**Re: Hornsby Quarry Road Construction Spoil Management Project (SSI 7066)**

Northern Sydney Public Health Unit would like to make the following comments on the EIS in regard to noise and vibration and air quality.

Figure 10 Cumulative 24-hour PM10 Occurrence at Receptor 327 (Hornsby TAFE)

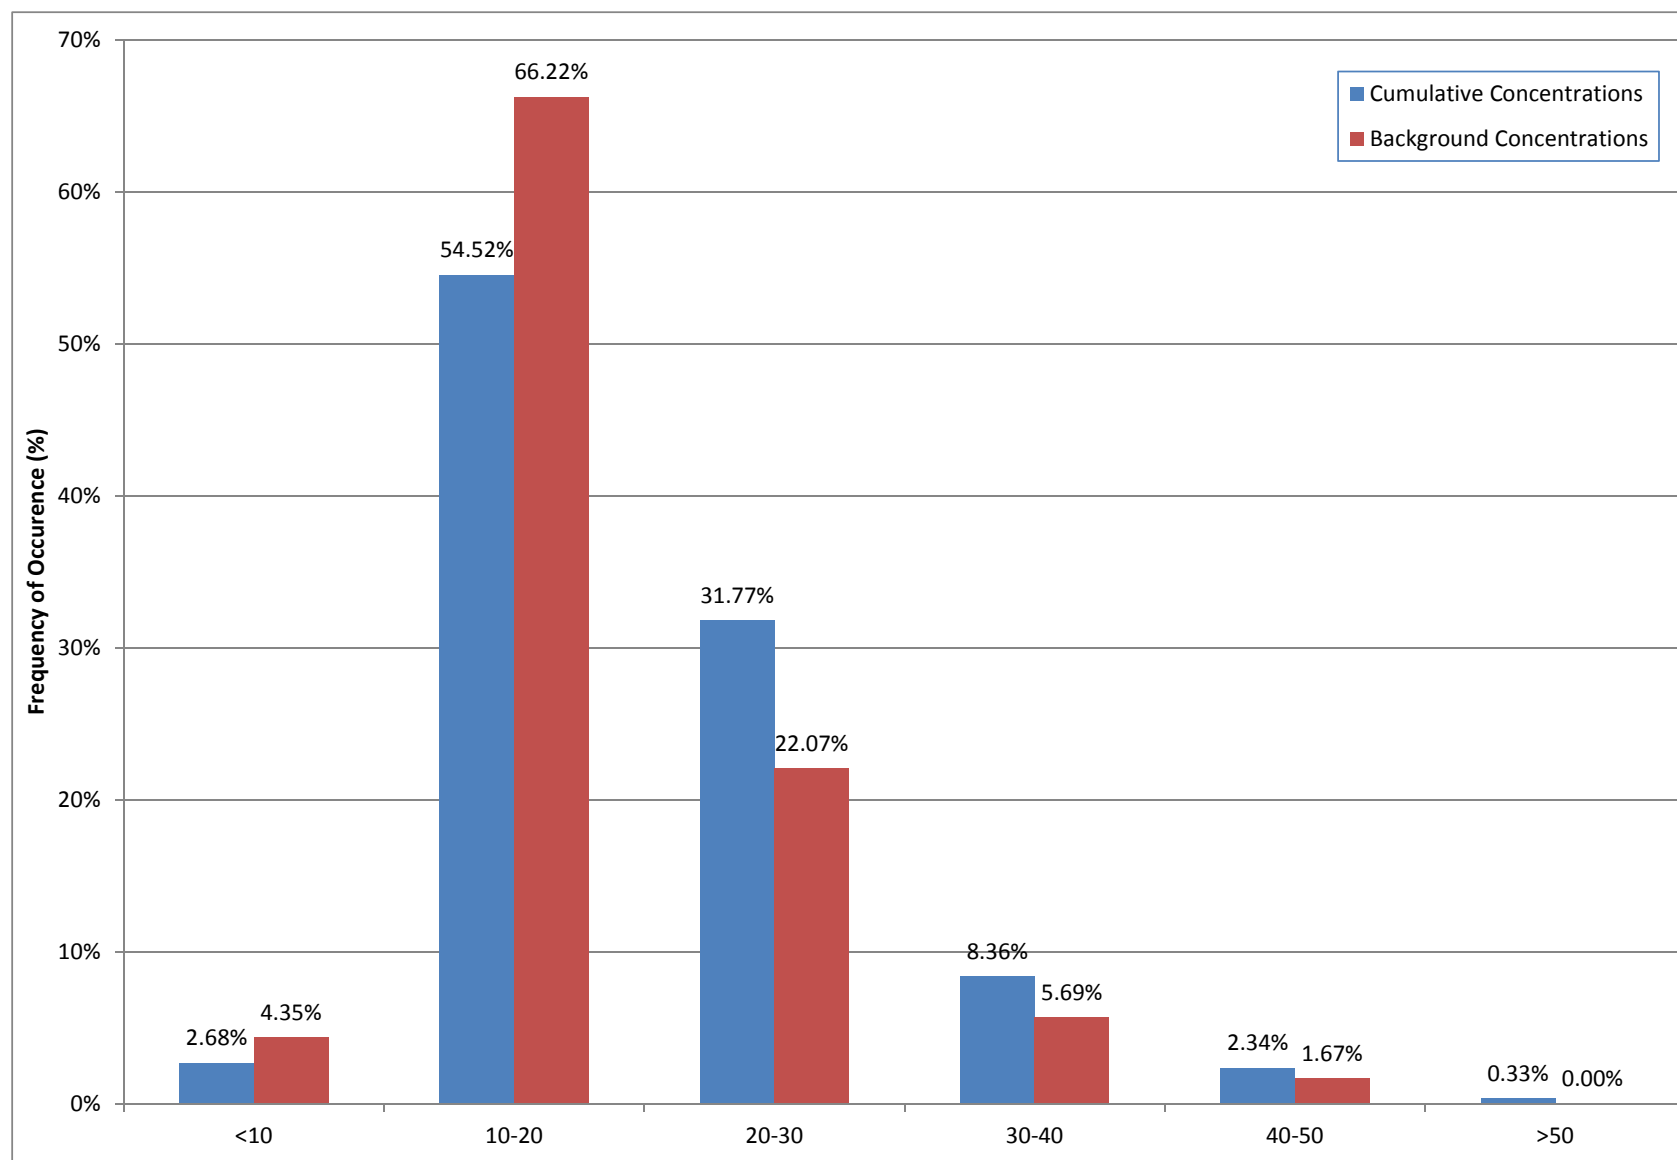
Hornsby TAFE and Mt Wilga Private hospital have been identified as sensitive land uses requiring a greater level of noise amenity. The Assessment indicates that these facilities will be exposed to outdoor construction noise of up to 74 (p 29) and 60 dB  $L_{Aeq(15 \text{ min})}$  (Appendix D Fig 1) respectively at times during the project. ICNG allows for a 10 decibel difference between external and internal noise levels (with windows open for adequate ventilation) resulting in corrected internal sound levels of up to 64 and 50 dB  $L_{Aeq(15 \text{ min})}$  respectively. These internal noise levels exceed ICNG internal NMLs of 45 dB  $L_{Aeq(15 \text{ min})}$  and substantially exceed WHO internal sound levels of 35 dB  $L_{Aeq}$  for school class rooms, and 30 dB  $L_{Aeq(16 \text{ hr})}$  for hospital ward rooms indoors. In view of these noise level exceedances both Hornsby TAFE and Mt Wilga Private hospital are significantly impacted by the project.
